Landscape & Green Infrastructure – Outputs

Exemplar Site

June Issue

Bicester eco-development
River Corridor Proposals
Drawing no. 8043-UA001881-02

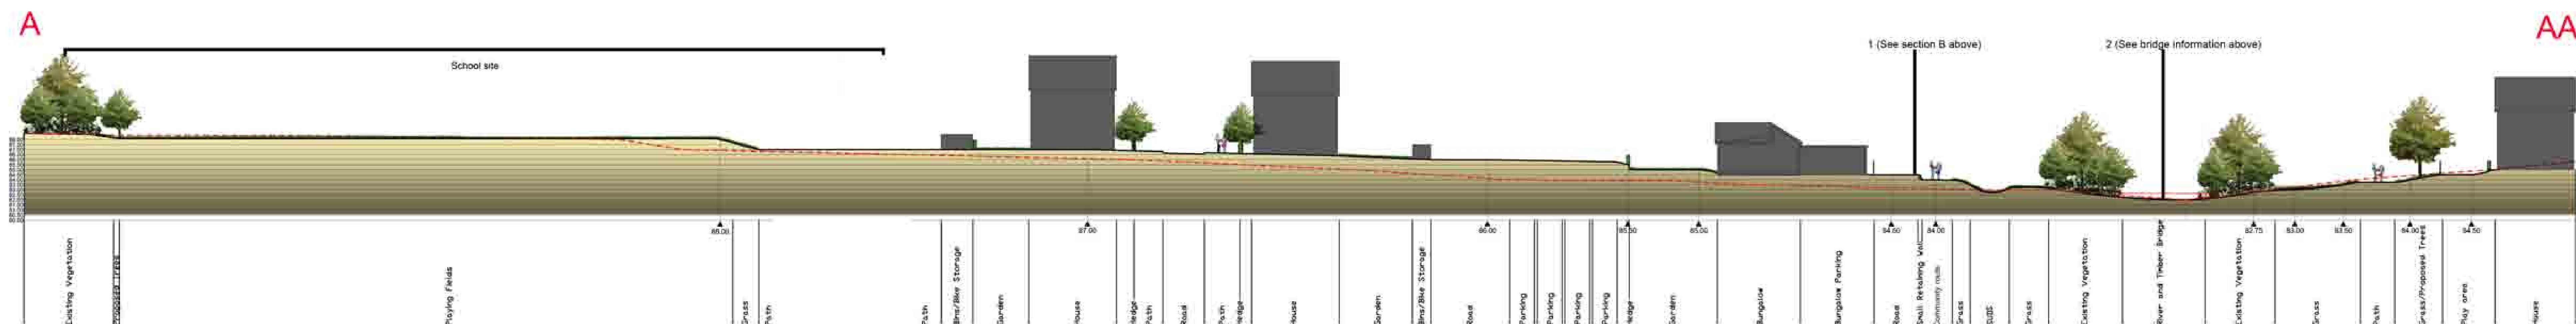
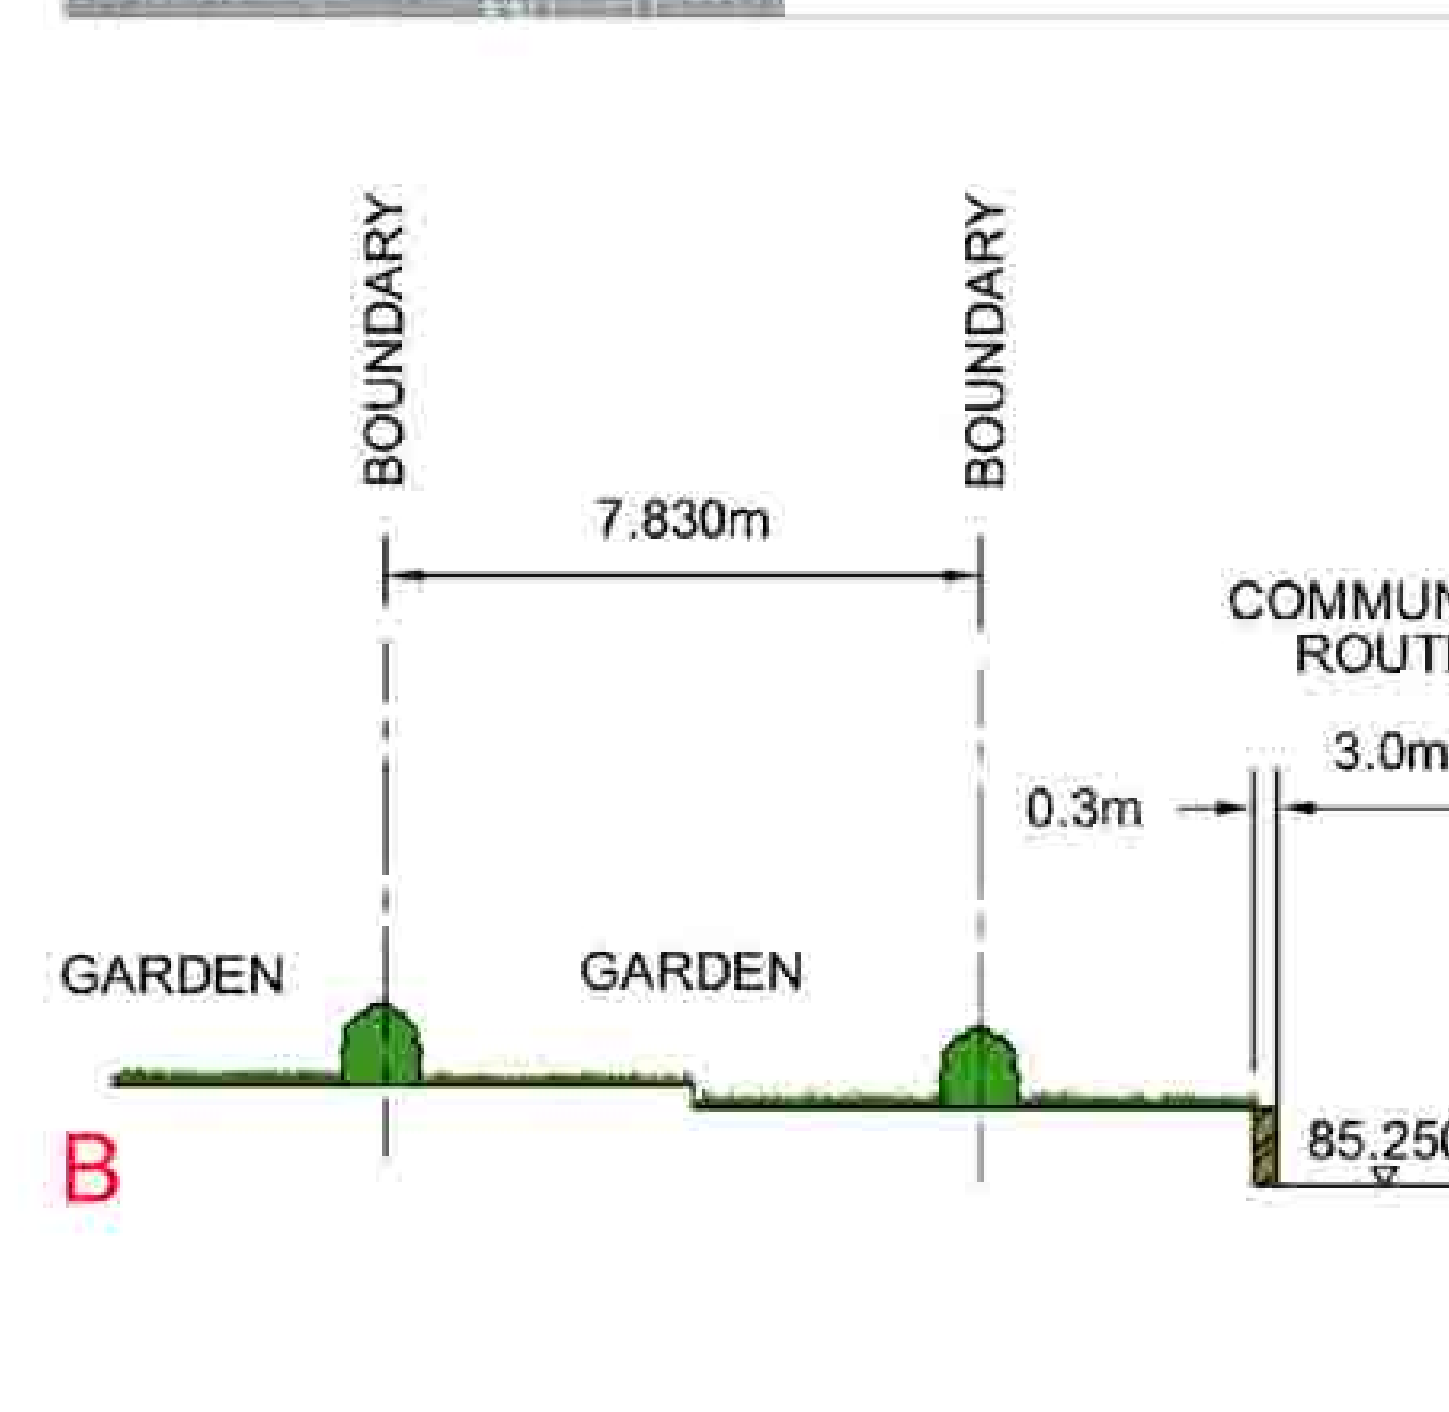
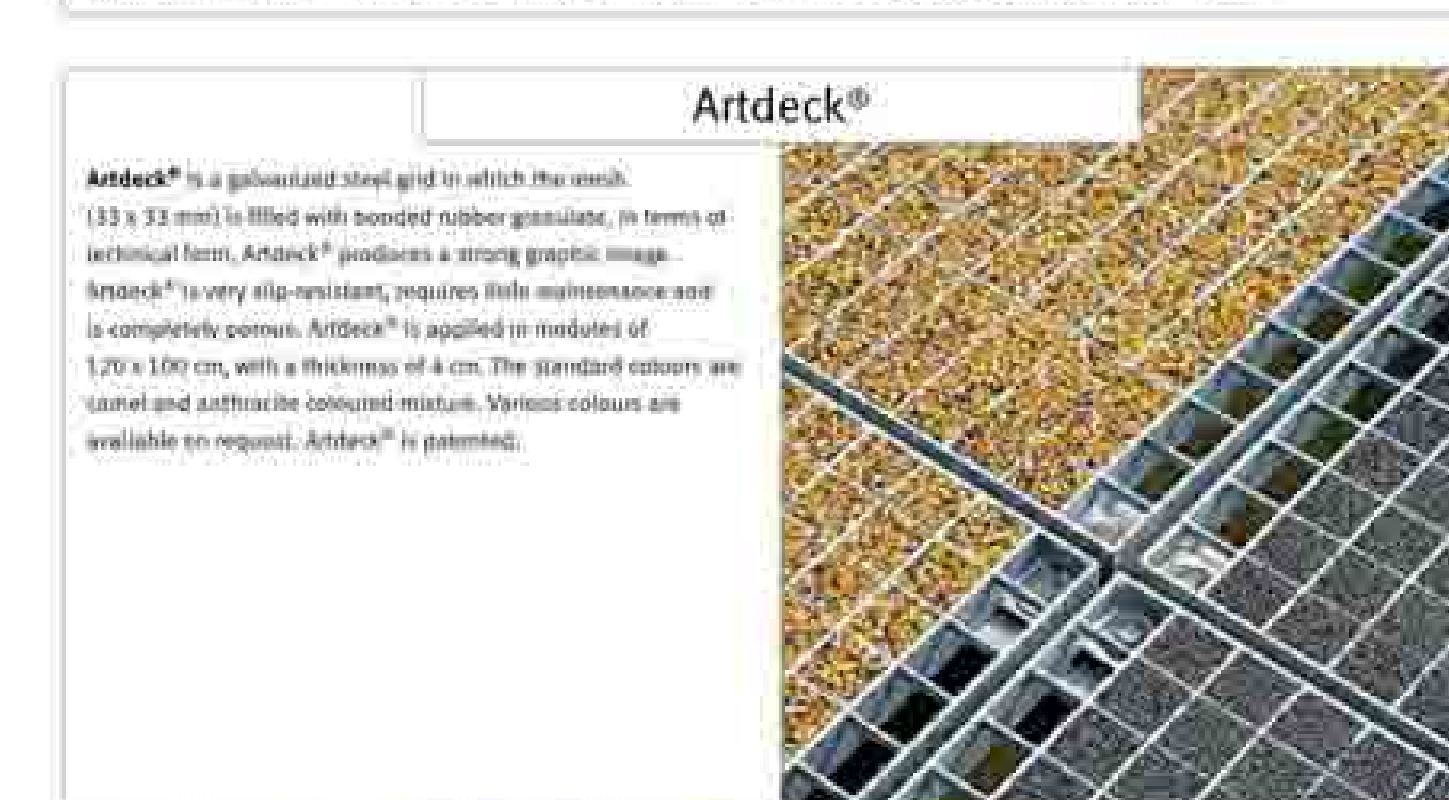
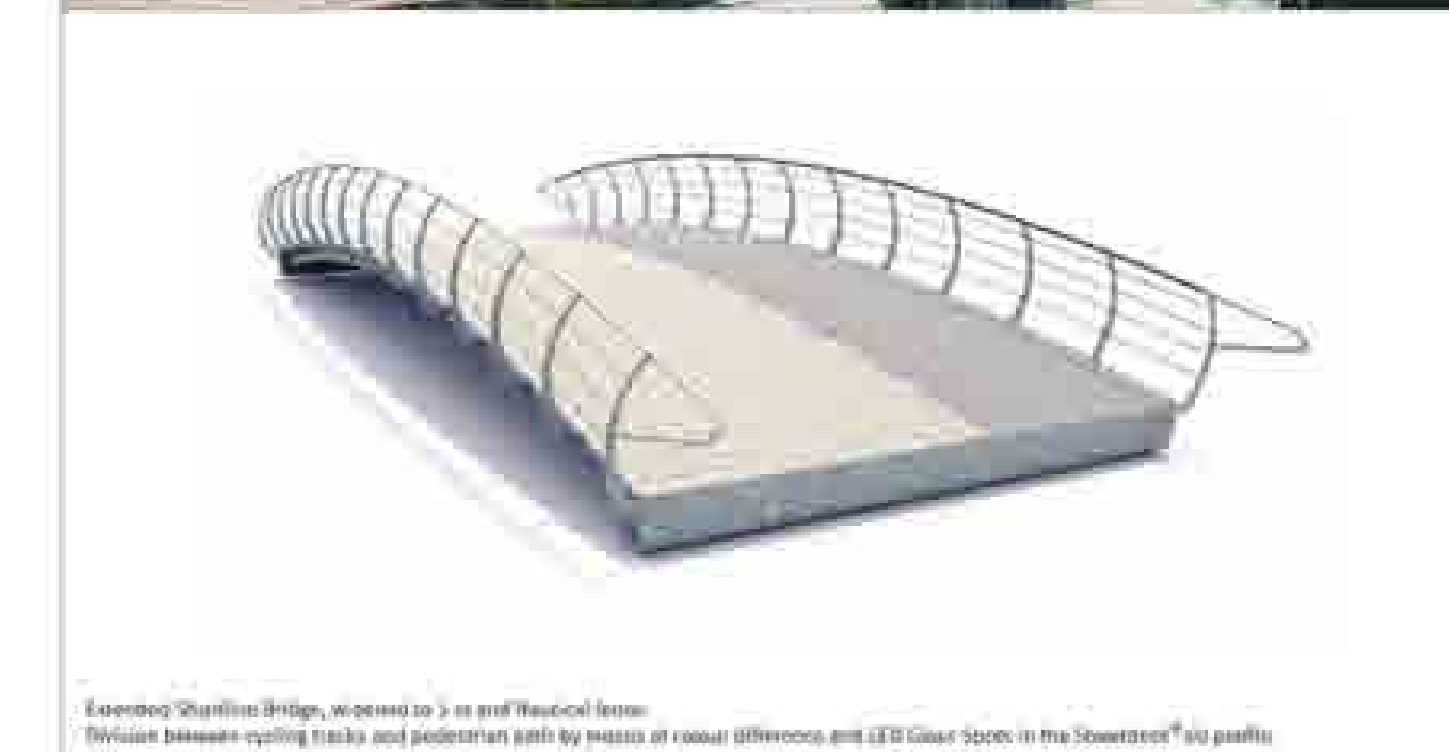
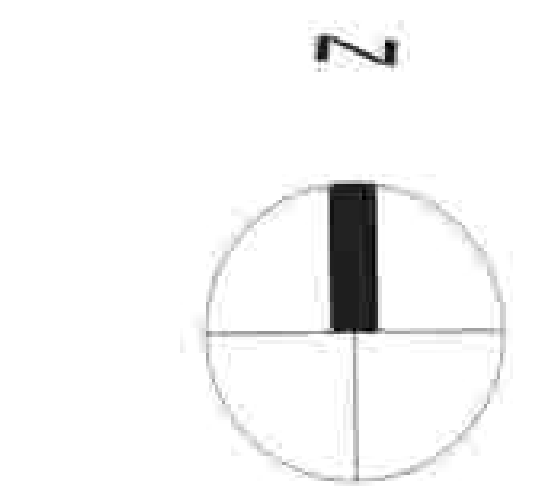
8039-UA001881-02	Parking Arrangement Turning Head, Plots 107-106, 127-130	Colour	1:125 Plan	A2	Approval	<ul style="list-style-type: none"> Tracking checked and graphic added Bin collection point relocated and parking overrun strip added Gate into Community Garden added
8040-UA001881-02	Parking Arrangement Plots 78-80, 94-96	Colour	1:125 Plan	A2	Approval	<ul style="list-style-type: none"> Tracking checked and graphic added Some trees removed / relocated to reflect tracking constraints and OCC concerns over proximity to parking bays
8041-UA001881-02	Parking Arrangement Exemplar Homezone, Plots 60-65 + Allotment Example 1	Colour	1:125 Plan	A1	Approval	<ul style="list-style-type: none"> Tracking checked and graphic added Planting areas reduced to accommodate tracking
8042-UA00188102	Allotment Example 2	Colour	1:125	A1	Approval	Updated to reflect up-to-date layout and landscape masterplan
8043-UA001881-02	River Corridor Section	Colour	1:250	A0	Approval	<ul style="list-style-type: none"> Revised to reflect contour proposals in river corridor Revised long section from school through bungalows and River Bure corridor Detailed section added to show relationship of community route, private gardens and river corridor Proprietary bridge crossings/ crossing detail and options added All as requested by CDC

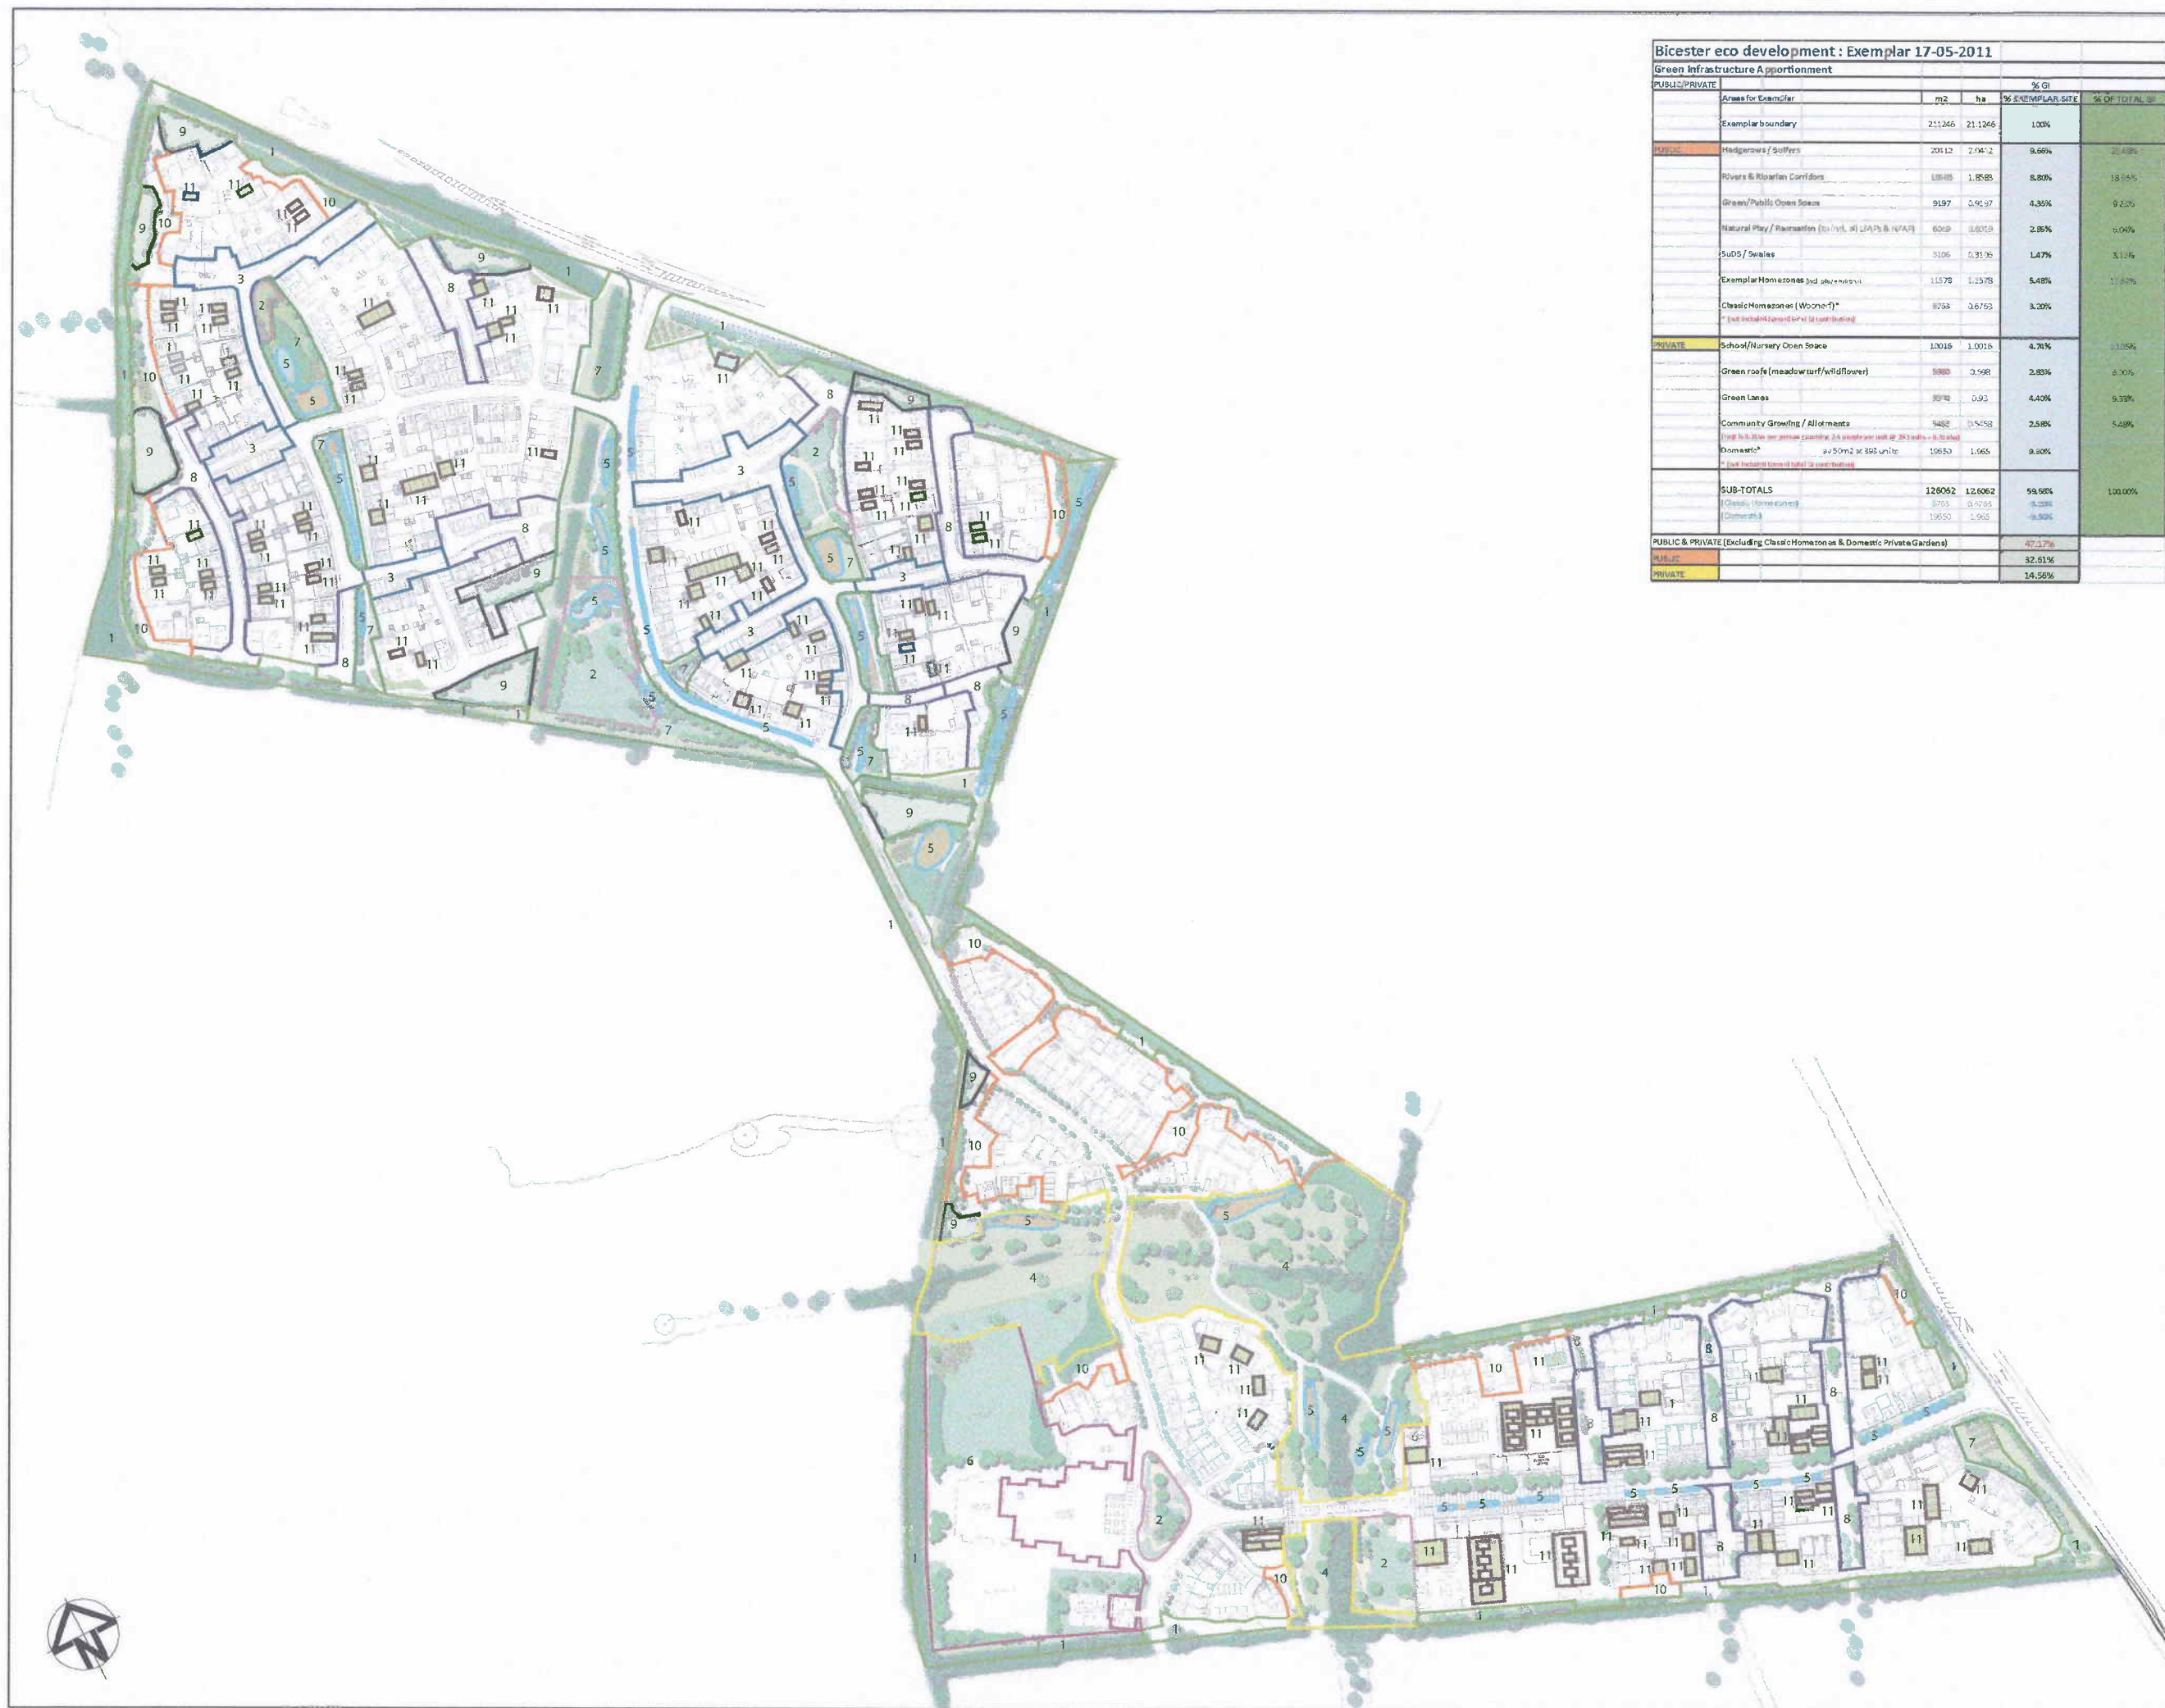
8044-UA001881-02	Homezone Territorial Diagram Example	Colour	NTS	A1	Approval	Updated to reflect changes to 8019
8045-UA001881-02	Green Infrastructure Typology & Apportionment	Colour	1:1000	A0	Approval	<ul style="list-style-type: none"> Updated through agreement with CDC, following several meetings and discussions Public Open Space aggregate calculation and diagram added at CDC request Removed all Woonerf/Classic Homezones for clarity
8046-UA001881-01	Allotment Example 2 Section	Colour	1:50	A1	WITHDRAWN	Considered of limited/no value
8047-UA001881-02	Energy Centre Streetscape Sections	Colour	1:50 + 1:100	A1	Approval	Amended in line with changes to 8029
8048-UA001881-02	Parking Arrangement Plots 280-281 Sections	Colour	1:50	A0	Approval	Amended in line with changes to 8034
